2024/0502**Applicant:** Miss Simone Tallis and Ms Jean Hancox**Address:** 9 Balkley Lane, Darfield, Barnsley, S73 9JE**Description:** Erection of rear conservatory to 2 storey terraced dwelling

Proposed Side

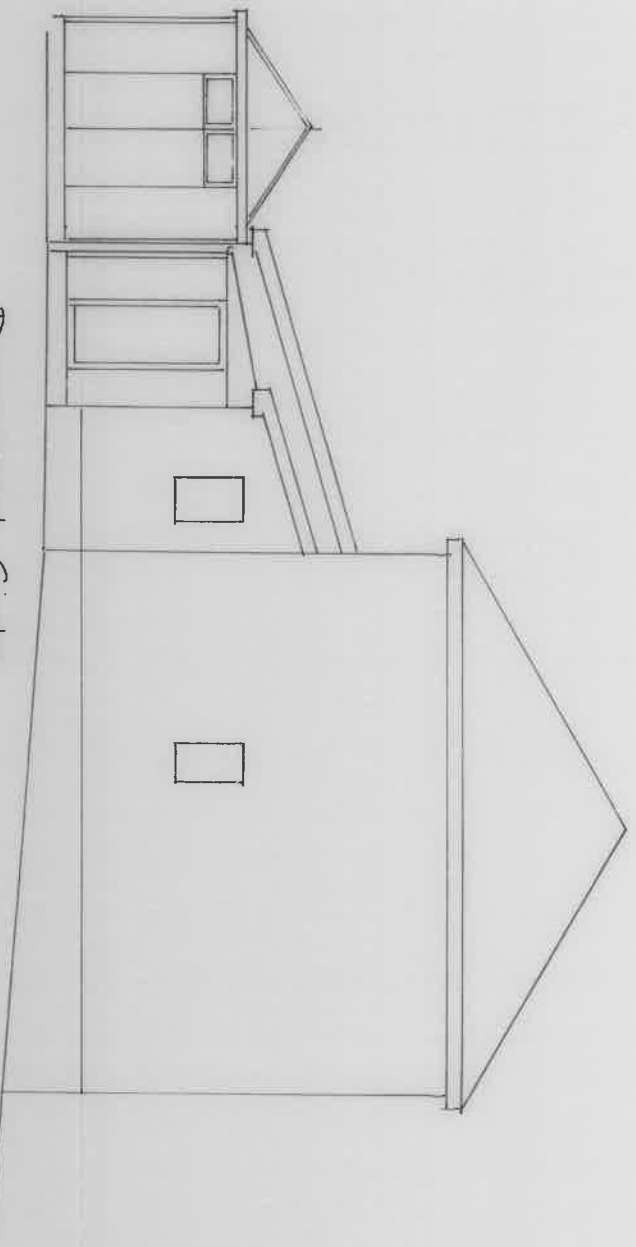
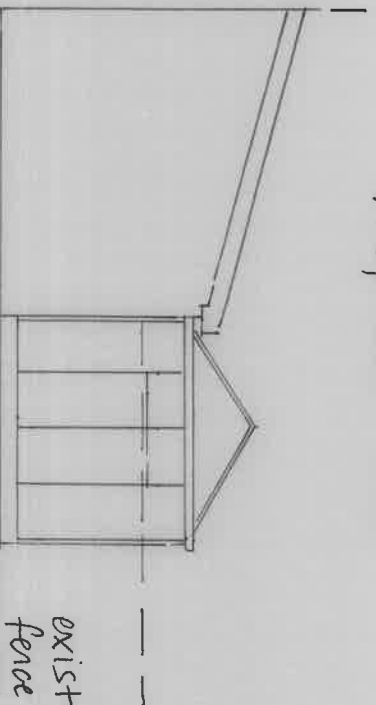
The proposed extension would replace an existing covered pergola, which is attached to the original extension, and may have required planning consent at the time of construction due to its proximity to the boundary, and its attachment to an existing extension. Having stated this, it is equally common for such structures to be incorrectly assumed as allowable through permitted development and does not appear to have caused any harm to the amenity of the neighbouring dwellings. The proposal seeks to replace this enclosure with a glazed conservatory, which would be of a very similar footprint but with a dual pitched roof with a maximum high point of 3.47m, this contrasts to the highest point of the original extension's sloped roof of 4.11m and its eaves height of 2.8m.

Separating the dwellings is a large timber fence, stated at being at a height of 1.8m which does appear correct but a discrepancy in the plans indicate the fence on the neighbouring dwelling's side is 1.9m, whilst the existing extension's and proposed conservatory's elevations are shown as approx. 10cm smaller. The varying land levels may account for this discrepancy, but the measurements from the application's garden would be used. In addition to the fence, the neighbouring dwelling has a shed adjacent to the fence. With the fence assumed to be 1.8m, the conservatory would be between 85cm at the eaves, and at the highest point, 1.67m higher than the fence. If the proposal had been for anything other than a glazed or transparent roof, additional concern would be raised, however it is a belief that this style of roof would support mitigation in relation to the potential overbearing nature of the proposed conservatory, when taken in consideration with the existing extension. Due to the high fence, privacy would not be a concern, and with a garden with west and south facing aspects, the neighbours garden to the north would not restrict natural sunlight into the neighbour's garden whilst the glazed nature of the conservatory would have less impact on overshadowing than the existing conservatory.
